Planning Officer: Mr S Davis

Planning Application Ref: Y/71/20/RES

Location: Land North of Yapton Church of England Primary School, North End Road, Yapton

Description of works: Approval of reserved matters following outline consent Y/88/18/OUT for the erection of 38 No. dwellings, Public Open Space, a play area & drainage features. This application affects Public Rights of Way.

INFILTRATION BASIN WITH INFILTRATION BLANKET BENEATH

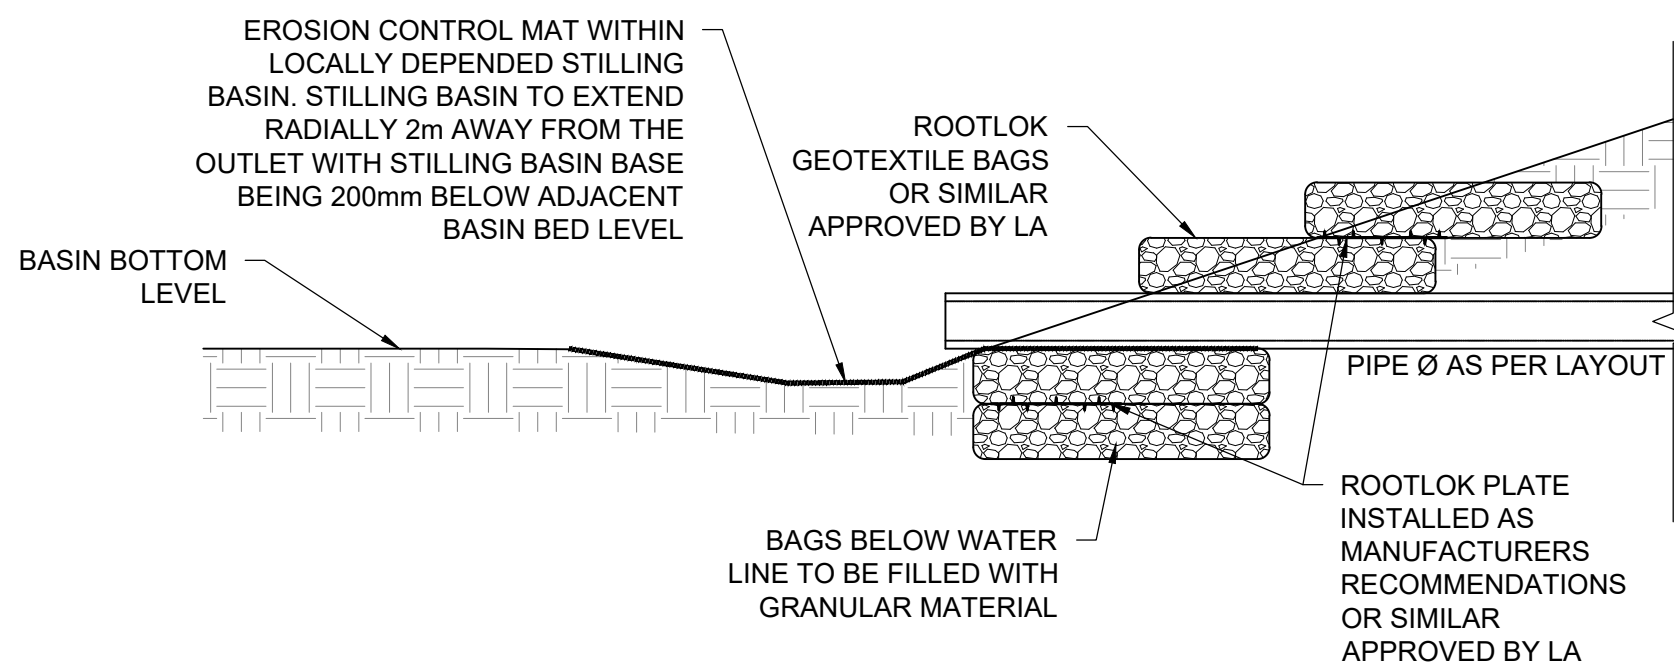
- Excavation into the RPA of T21 (and removal of T20) to accommodate the Infiltration Basin is undesirable from an arboricultural perspective and may also be unacceptable to our Drainage Engineer given growth potential of the former.

- There does not appear to be an approvable surface water drainage strategy for the site. This fundamental element of the design ought to be addressed to our satisfaction in association with layout proposals, so that we are not subsequently held hostage to flood mitigation measures which could then impact heavily on retained trees/landscape plans/open space provision.
